KRISTEN ESTATES FINAL PLAT CONSTRUCTION DOCUMENTS

EPC STORMWATER REVIEW COMMENTS
IN ORANGE BOXES WITH BLACK TEXT

KRISTEN ESTATES
EL PASO COUNTY, COLORADO
CONSTRUCTION DOCUMENTS
COVER SHEET

PROJECT NO.
196663001

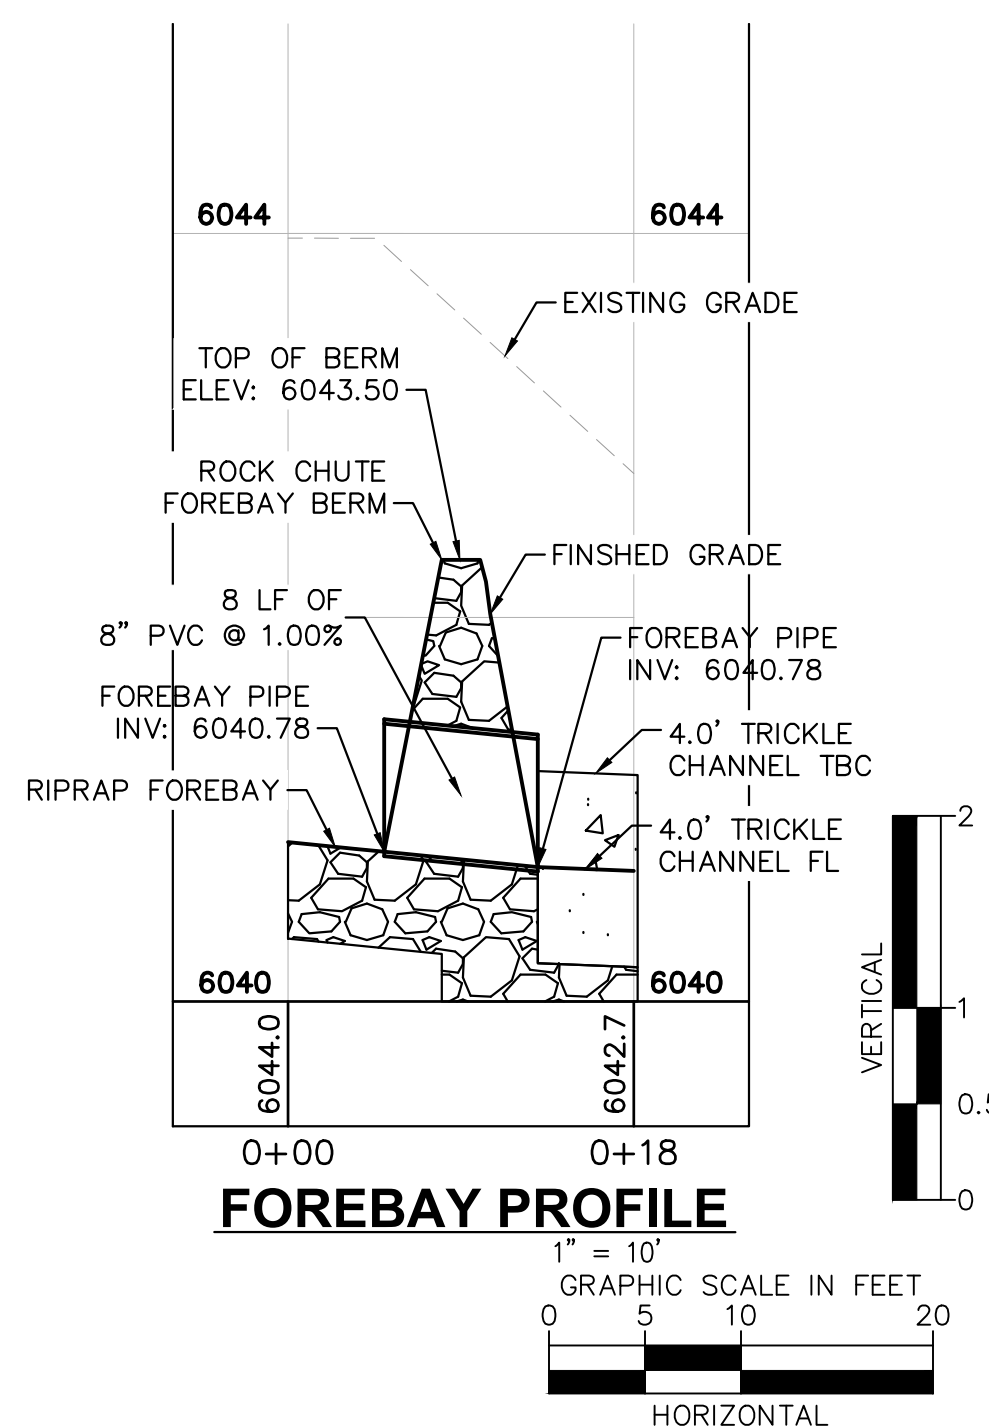
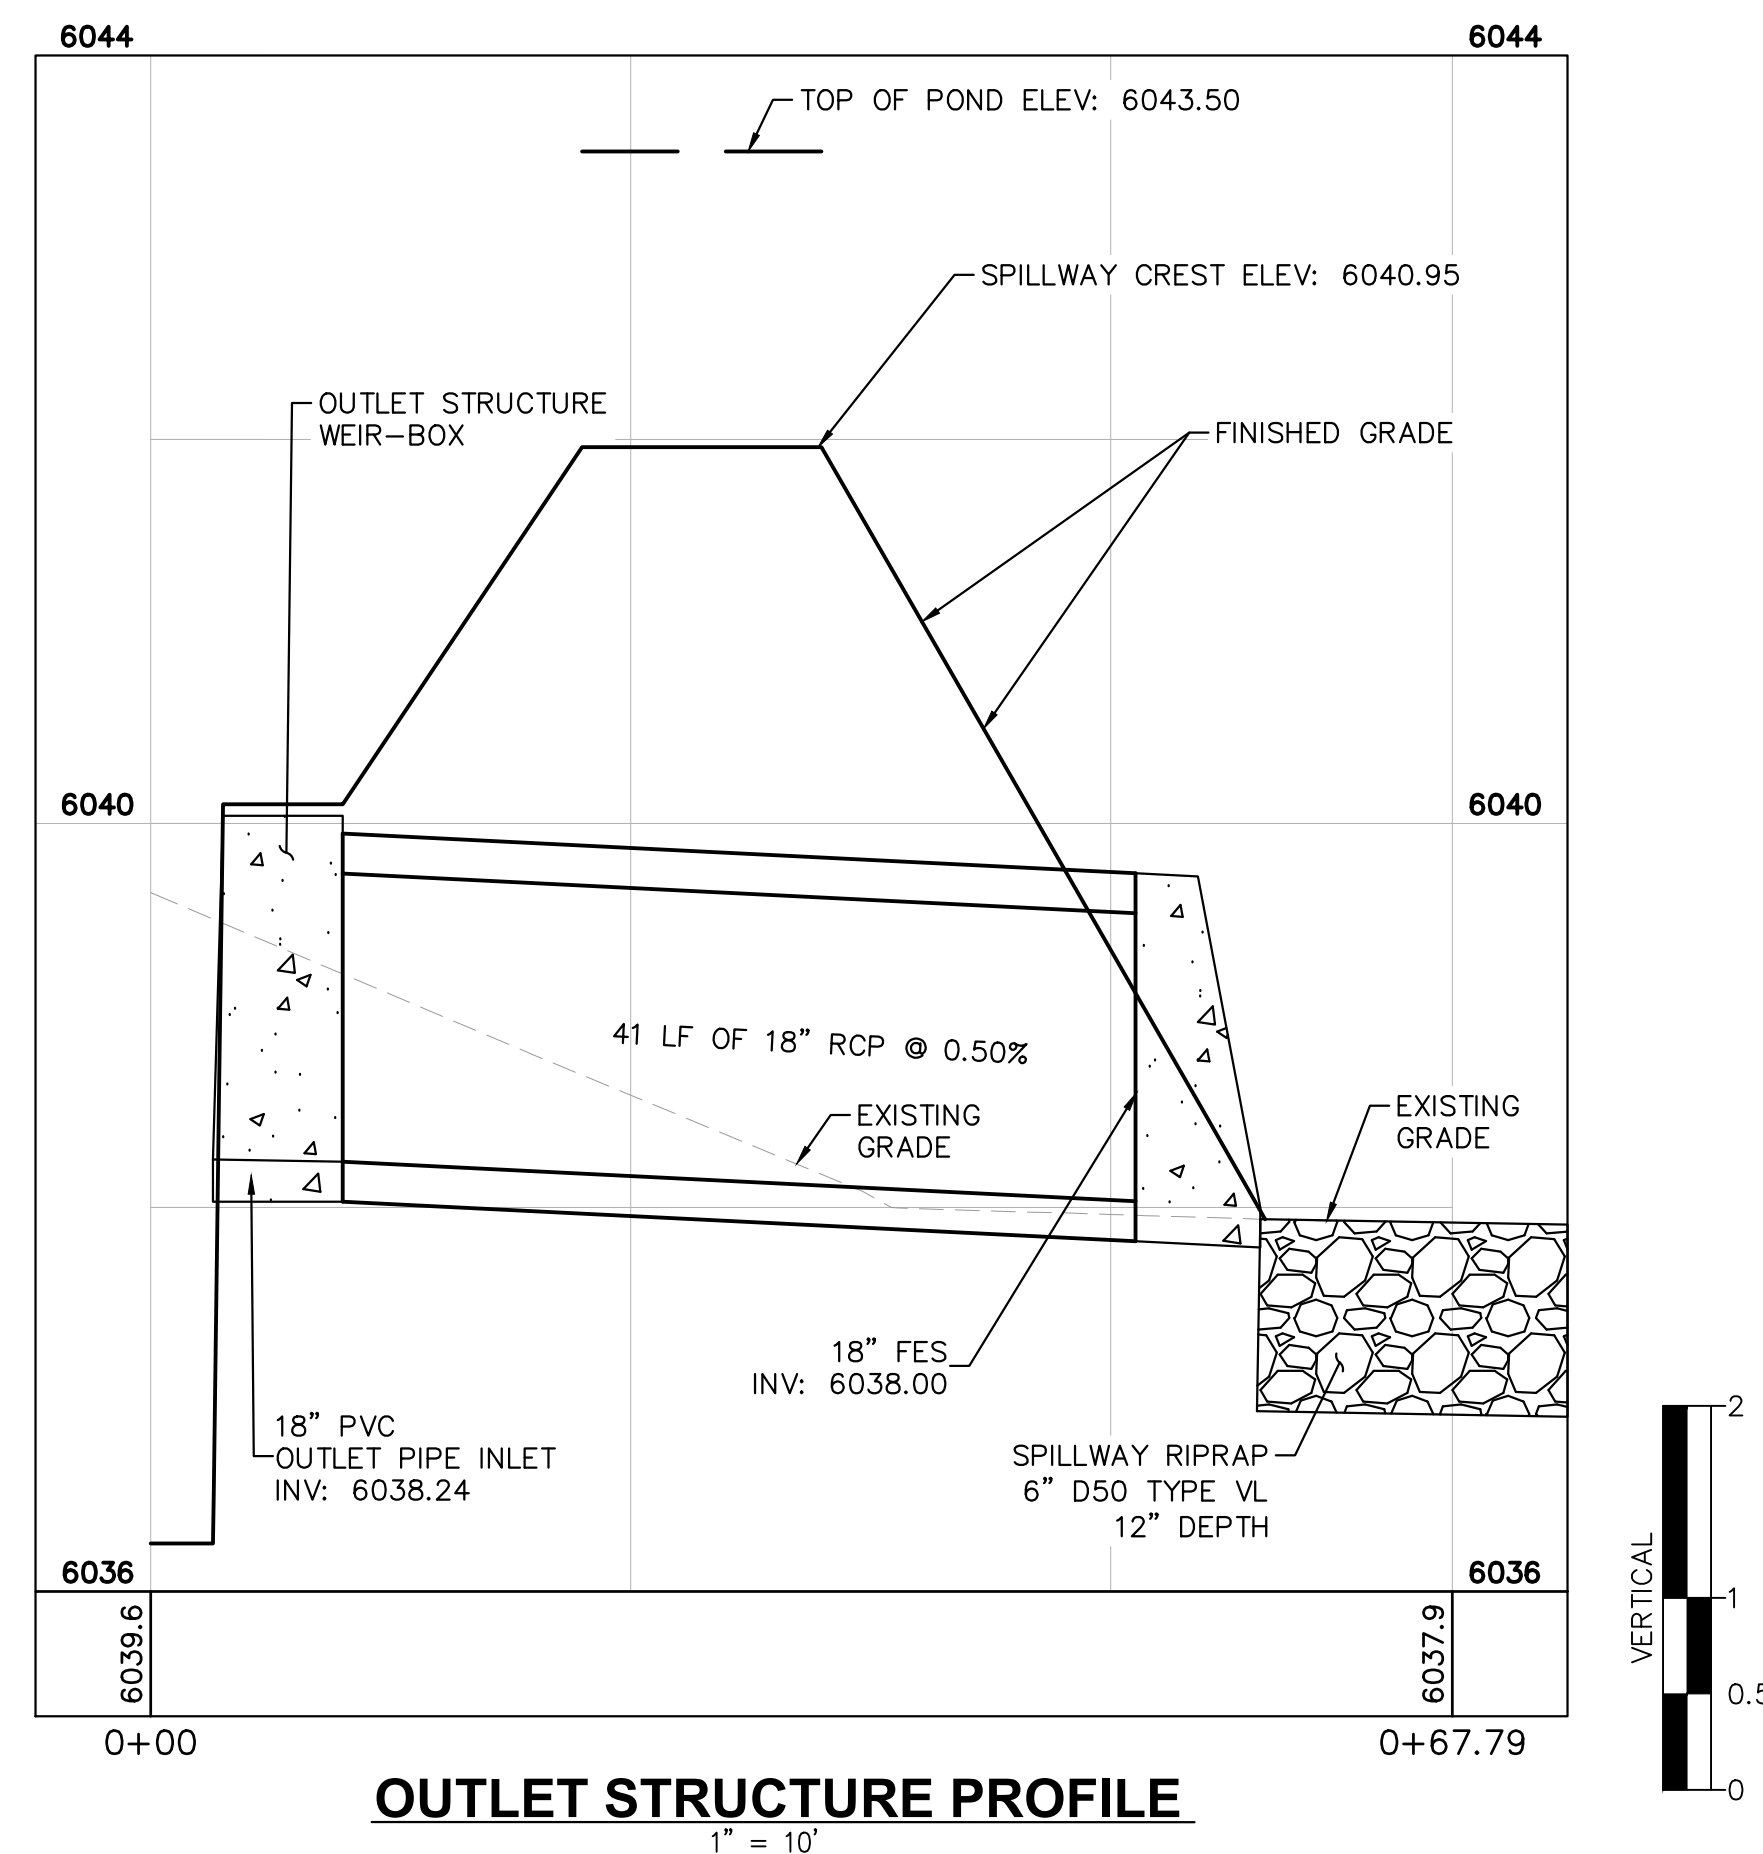
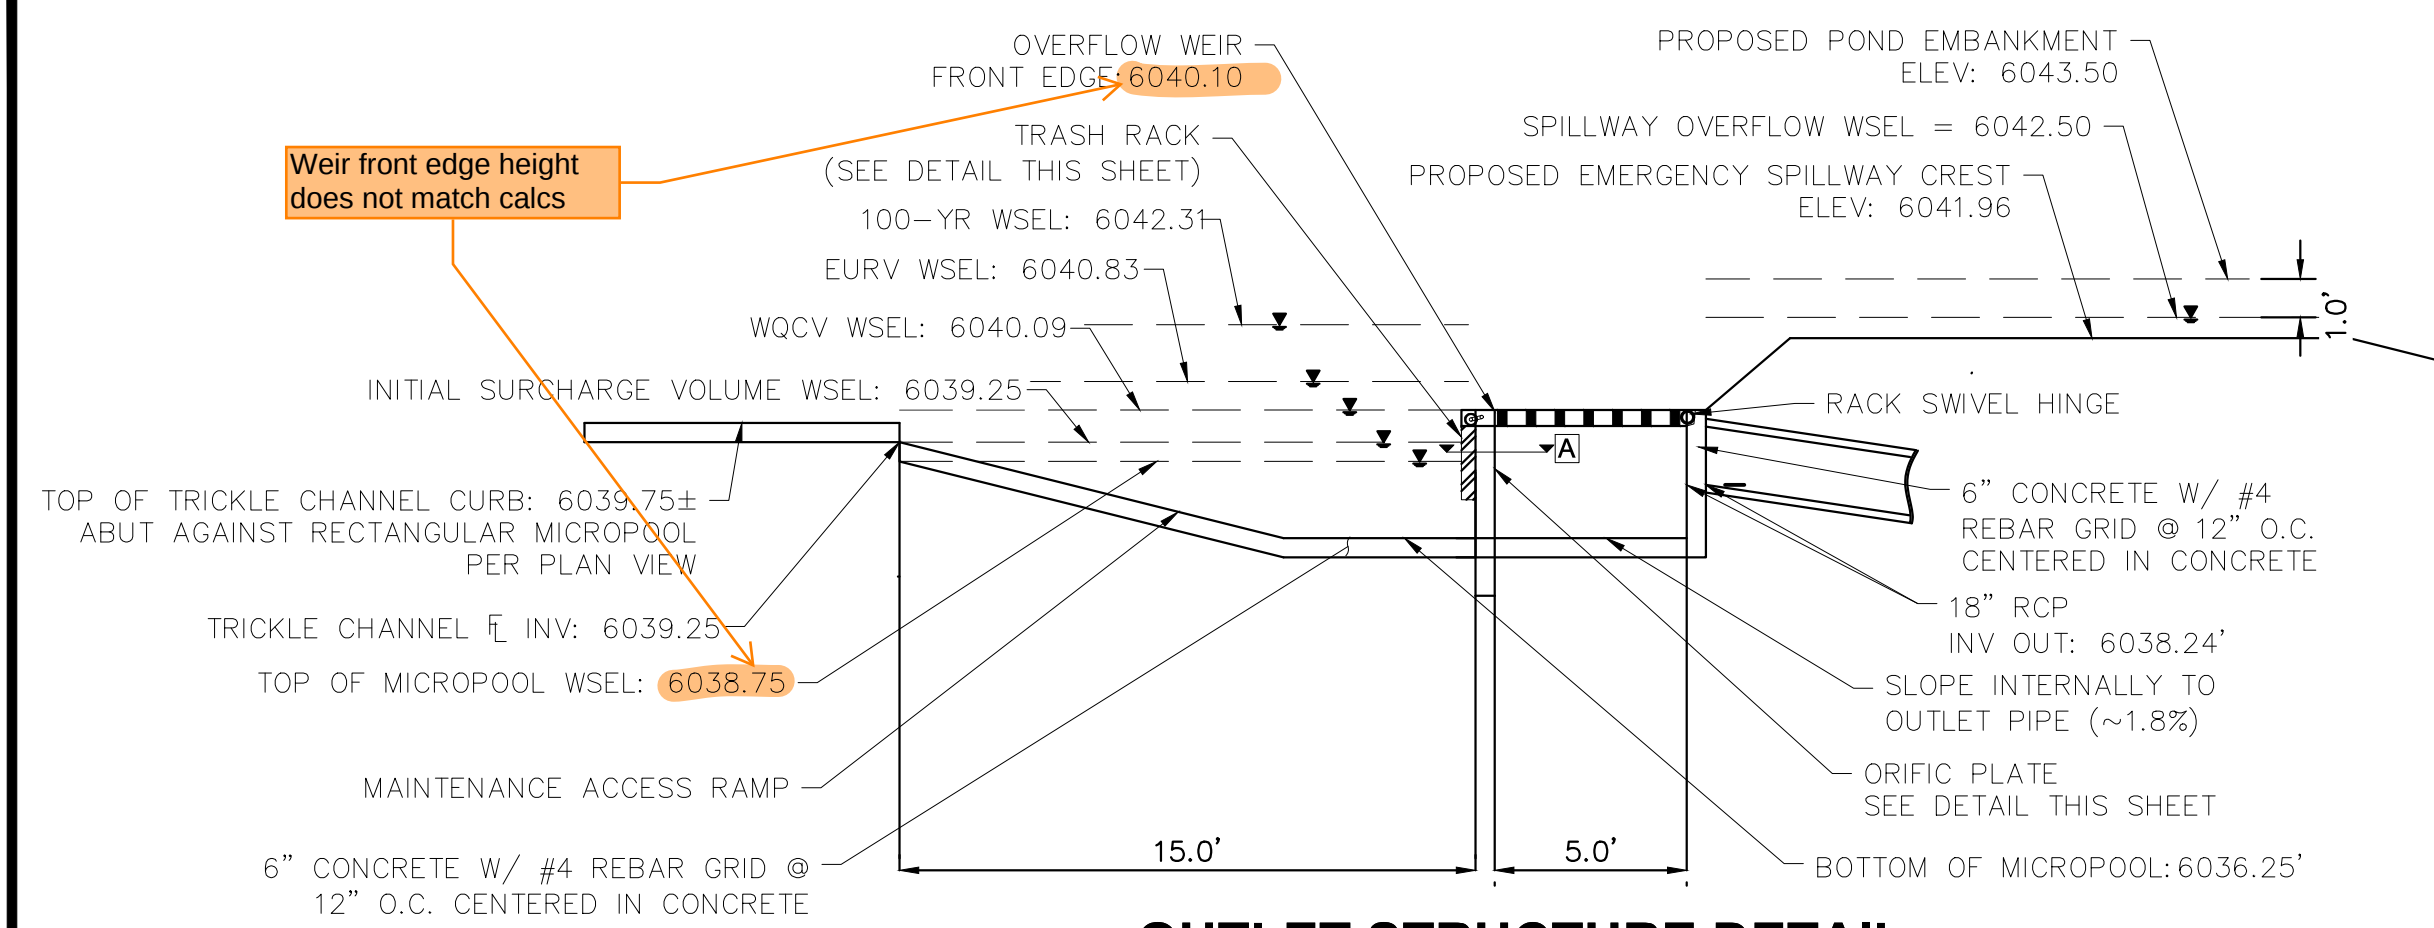
Provide the location of the cistern and the required turn out a dry hydrant.
